**Response to Highways Authority Comments ;
Parking Management Plan**

Planning Ref: 78905/APP/2025/688

25 Gledwood Crescent, Hayes, UB4 0AX

Date: 09/2025

TITLE: Proposed Ground and First Floor Plans

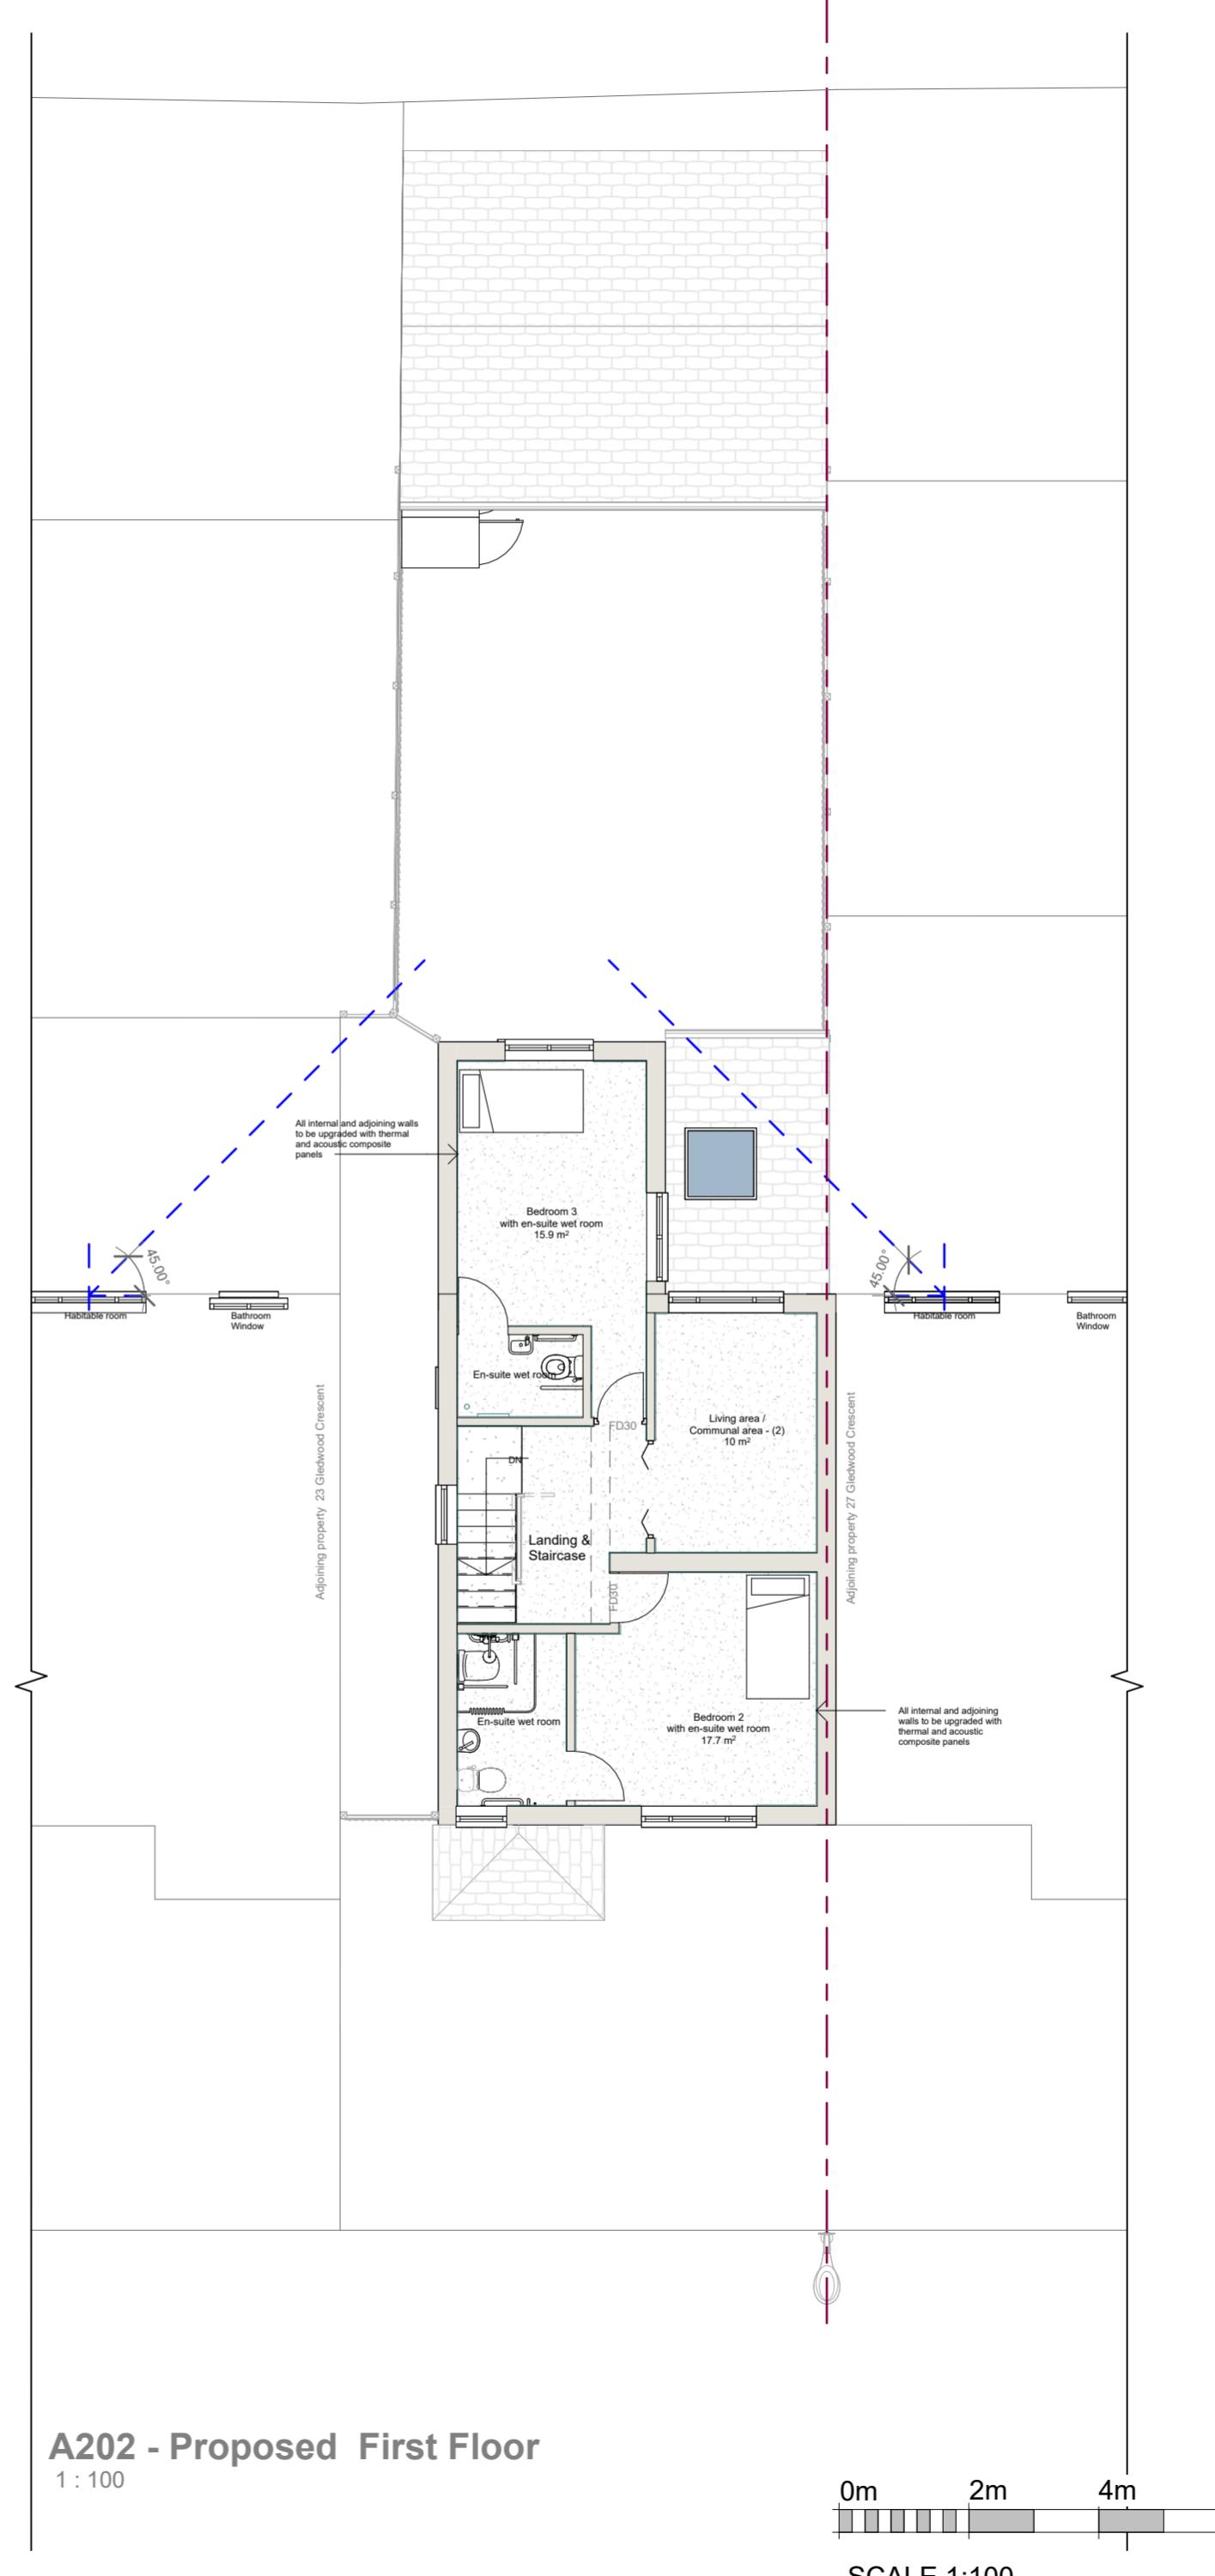
Only one parking space appeared achievable because of the existing lamp column and single crossover. The forecourt width seemed insufficient for two vehicles, and there were concerns about local parking stress on Gledwood Crescent.

Uncertainty about how ambulances, taxis, and service vehicles could access the property safely without blocking the carriageway or footway.

- The lamp post relocation and dropped-kerb extension have been formally approved by the Council's Highways Department (see attached approval letter).
- These approved works provide two off-street parking bays, each 4.8 m x 2.4 m, accessed via the widened crossover.
- The existing porch will be removed, increasing forecourt depth to 6.3 m and overall width to 7.4 m, enabling vehicles to park wholly within the site.
- The revised frontage layout provides a minimum 1.0 metre clear space in front of the main entrance and along the side access, surfaced in durable, non-slip paving to ensure safe and unobstructed movement for residents, visitors, and emergency personnel. This surface treatment clearly separates pedestrian routes from vehicle areas, maintaining accessibility and full compliance with Hillingdon Local Plan Policy DMHB 11 (Inclusive Design) and Building Regulations Part M.

- The widened crossover and 7.4 m frontage allow direct access for ambulances, taxis, and deliveries entirely within the property boundary.
- The forecourt functions as a temporary drop-off area, keeping the public footway clear.
- On-duty staff will supervise emergency or delivery access to maintain safety.
- Servicing and deliveries (e.g. medication, food, maintenance) will occur 10:00 AM – 4:00 PM weekdays only.
- Refuse collection remains kerbside, consistent with neighbouring dwellings.

- Two off-street parking bays (each 4.8 m × 2.4 m) will be provided within the site frontage, accessed via the approved extended crossover.
- The existing porch will be removed, increasing forecourt depth to 6.3 m and total frontage width to 7.4 m, enabling vehicles to park fully clear of the footway.
- A 7 kW active EV charging point will serve both bays.
- A minimum 1.0 m-wide clear pedestrian walkway in contrasting paving will run in front of the entrance and side access, ensuring safe step-free access.
